Planning App Ref: 2024/62/92626/W

Objection to the planning application for the removal of equine buildings/structures and erection of detached dwelling at Malkin Farm, Brow Lane, Holmfirth, HD9 2RJ.

Drawing Title/Issue
Existing Block Plan

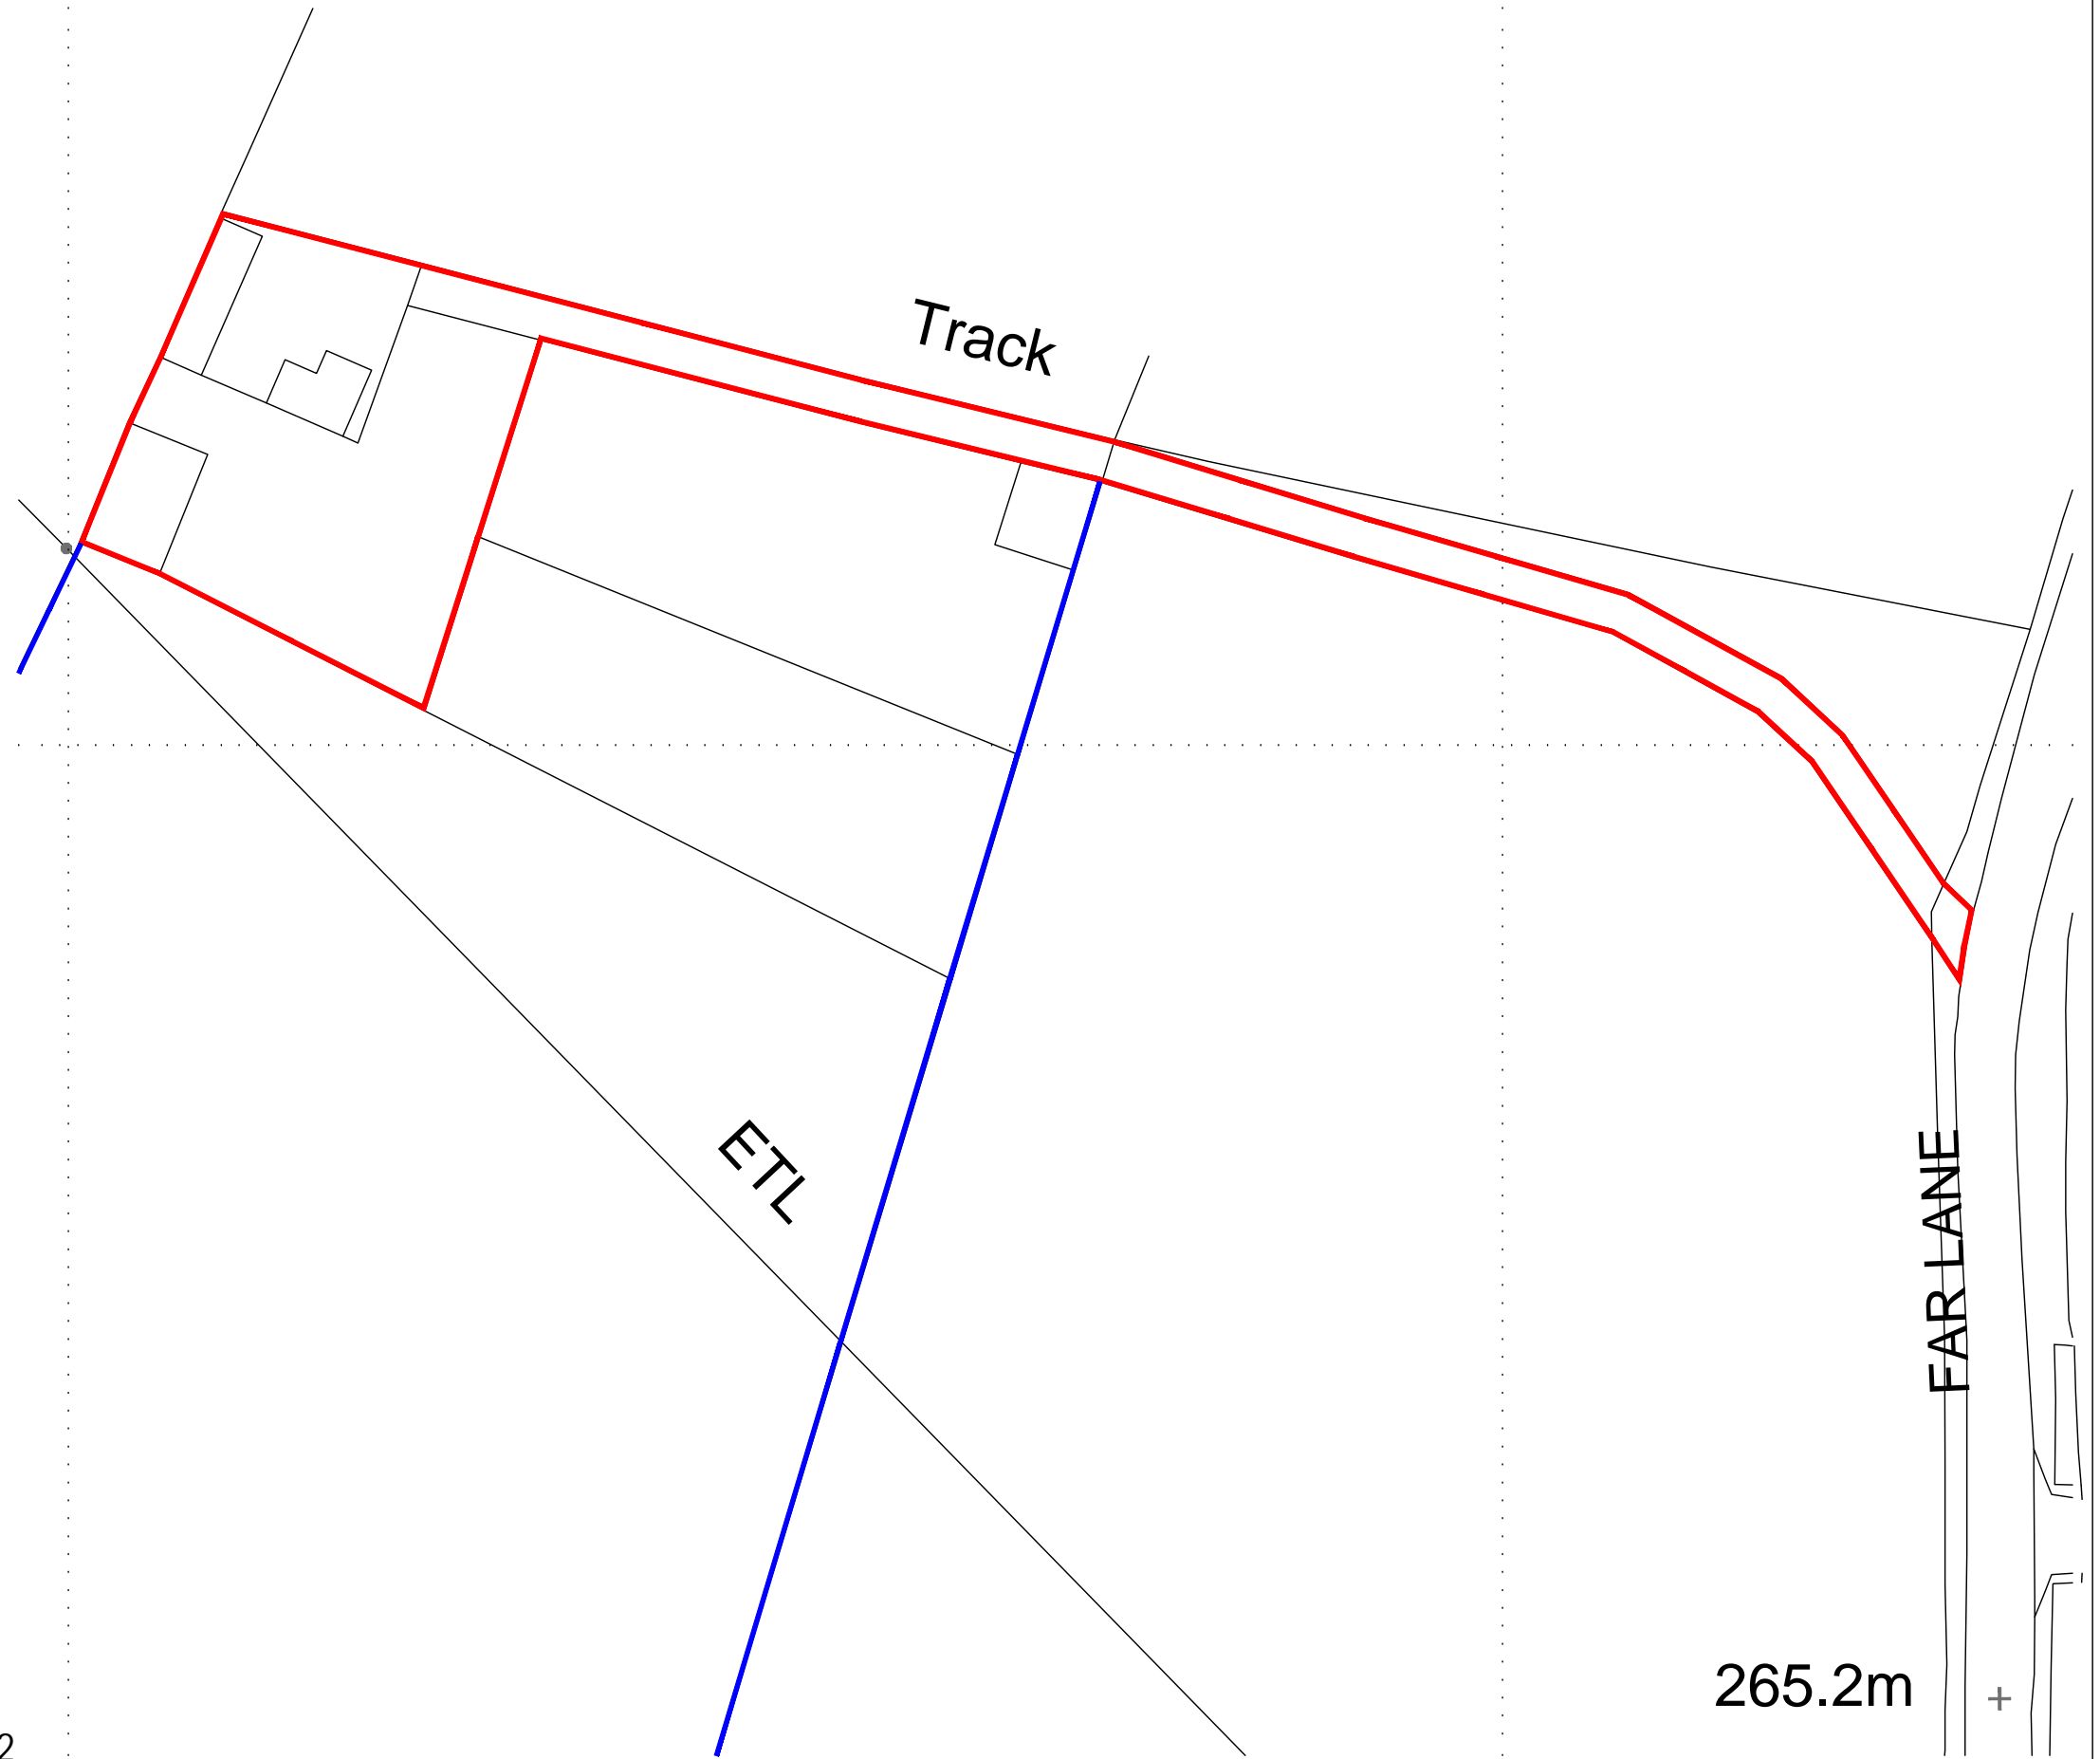
The site currently comprises a collection of eight buildings comprising a barn, three stables, three stores and a caravan laid out around an informal yard. It is recognised two of the stores (the sheds) and the caravan have not been included in volume calculations as these are temporary buildings.

The existing layout of buildings and site are shown in the drawings and photographs below which show the site comprises a simple agricultural form. The photograph below shows the land slopes from west to east with the highest part of the site being the western part where the barn is currently located. The barn, stables and a store lie along the western edge of the building following the line of an existing stone wall. The remaining buildings are clustered to the east on a lower part of the site.

The existing buildings (barn, stable and store 3) have a gross footprint of 110m² and a volume of 322m³. The proposed development increases the footprint of the building to 135m², the volume is quoted as 20m³ less than the existing buildings.

Policy LP59 of the Kirklees Local Plan relates to the development of brownfield sites in the Green Belt. The policy states the footprint of existing development should not be exceeded. As referred to above, the proposed building footprint extends to 135m² compared to the existing building footprint (excluding the temporary structures) of 110m². As such the application does not comply with Policy LP59 of the Local Plan.

General Arrangement as Proposed

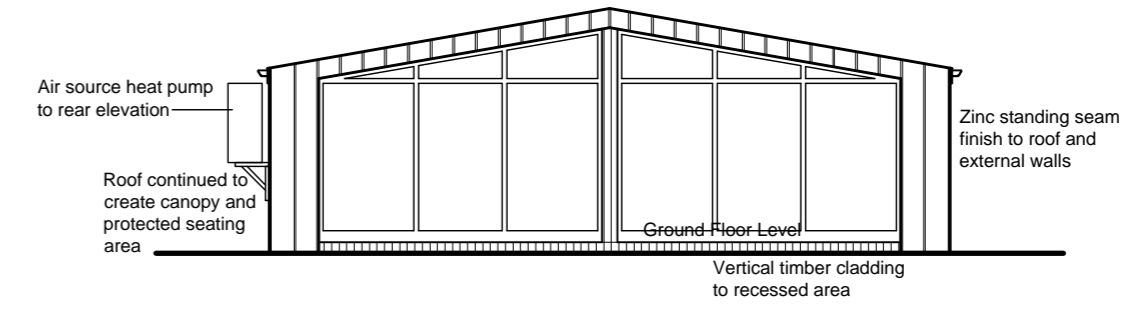
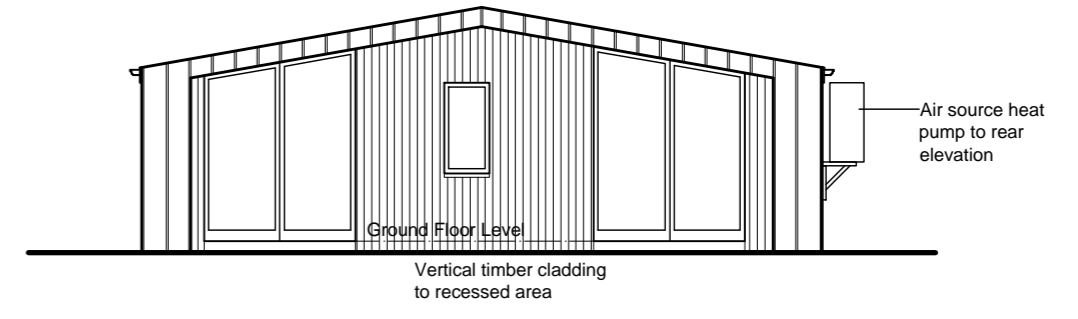
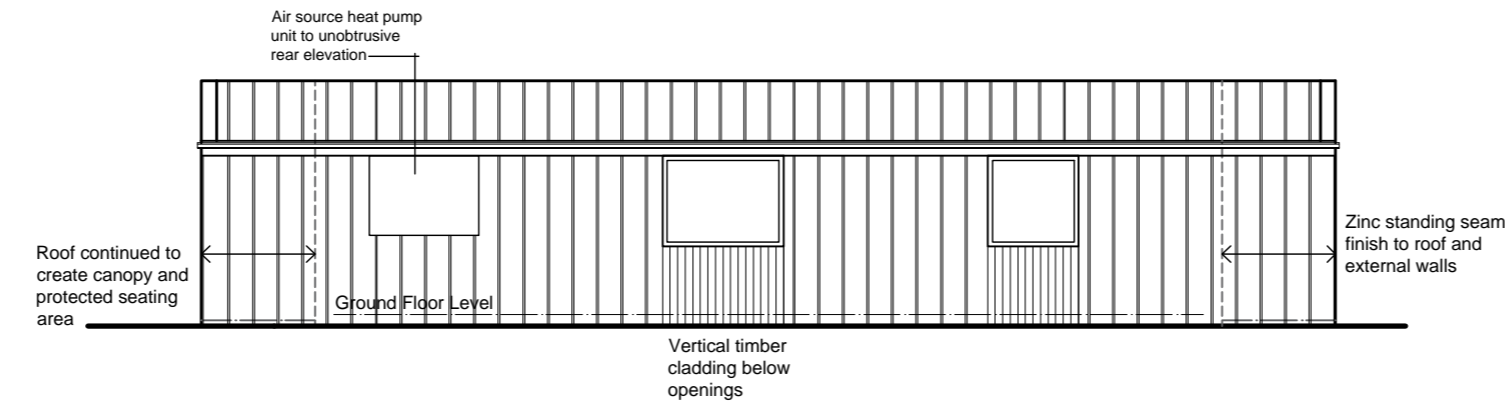
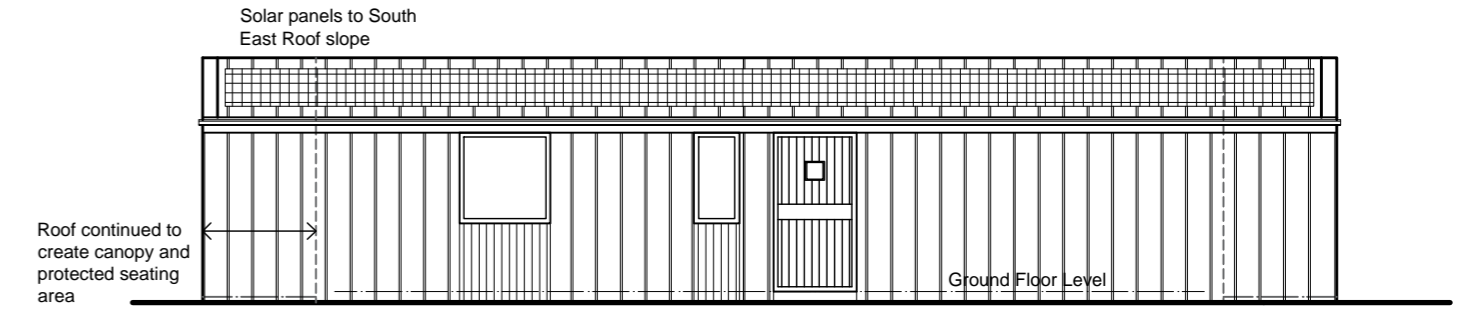
The proposed development comprises a design which incorporates a 3-bedroom residential dwelling resulting in a slightly reduced total volume of 301.20m³ compared to the existing volume on the site. The proposed development creates a single rectangular building with a floor area of 135m² with a shallow pitch roof. The height of the pitch is 3.2m above ground level, the eaves are at 2.5m above ground level. The building is proposed to be located on part of the footprint of the barn and partly the caravan/ stores. It is not clear from the plans whether a development plateau will be created to address the difference in ground levels shown on the existing sections.

There would be a substantial increase in the overall layout, massing/bulk of built form on the site compared to the existing built form comprising smaller individual structures of simple form and less physical bulk.

The proposed development would result in a more physically imposing structure as a result of its increased form, mass and height. Consequently, the proposal would result in a greater impact on openness than the existing development and would therefore be inappropriate development in the Green Belt as defined by NPPF.

The proposed development would replace the existing collection of buildings with a single substantial built form of greater height than the existing buildings. The footprint of the proposed dwelling does not follow the existing built form, with the proposed building sitting more prominently within the site, details of the designated external domestic space have not been provided.

The development would result in a prominent domestic dwelling on the site, creating a single bulk and mass. The proposed dwelling is higher than the existing barn and other buildings on the site which are lower and sit within the landscape and are screened from the west by the existing wall from some views. The proposed dwelling would extend above the existing wall and its position within the site, bulk and mass would impact on the character and appearance of the area, particularly in respect of long views of the valley from Penistone Road and Sheffield Road towards Hepworth village.

There is no definition in the policy of 'materially larger', however we consider a 25% increase in the footprint would be considered materially larger and in this instance the form results in a new building that is disproportionately larger in form than the existing collection of buildings in equine use. As such we do not consider the proposal complies with part b of the policy.

Criteria c of the policy relates to the impact on openness, we have addressed this above but note the existing cluster of building integrate into the natural slope and character of the landscape and are not 'prominent'. The proposed dwelling would replace the existing buildings with a higher, single prominent structure resulting in an increased mass and form which impacts openness and would harm the Green Belt.

Part d of the policy refers to design and materials. We note the design of the building seeks to echo and agricultural building, although do not consider the design is of high quality or appropriate in this location. Notwithstanding this, the principle of the development has not been established and therefore we do not wish to comment on this aspect further at this stage.
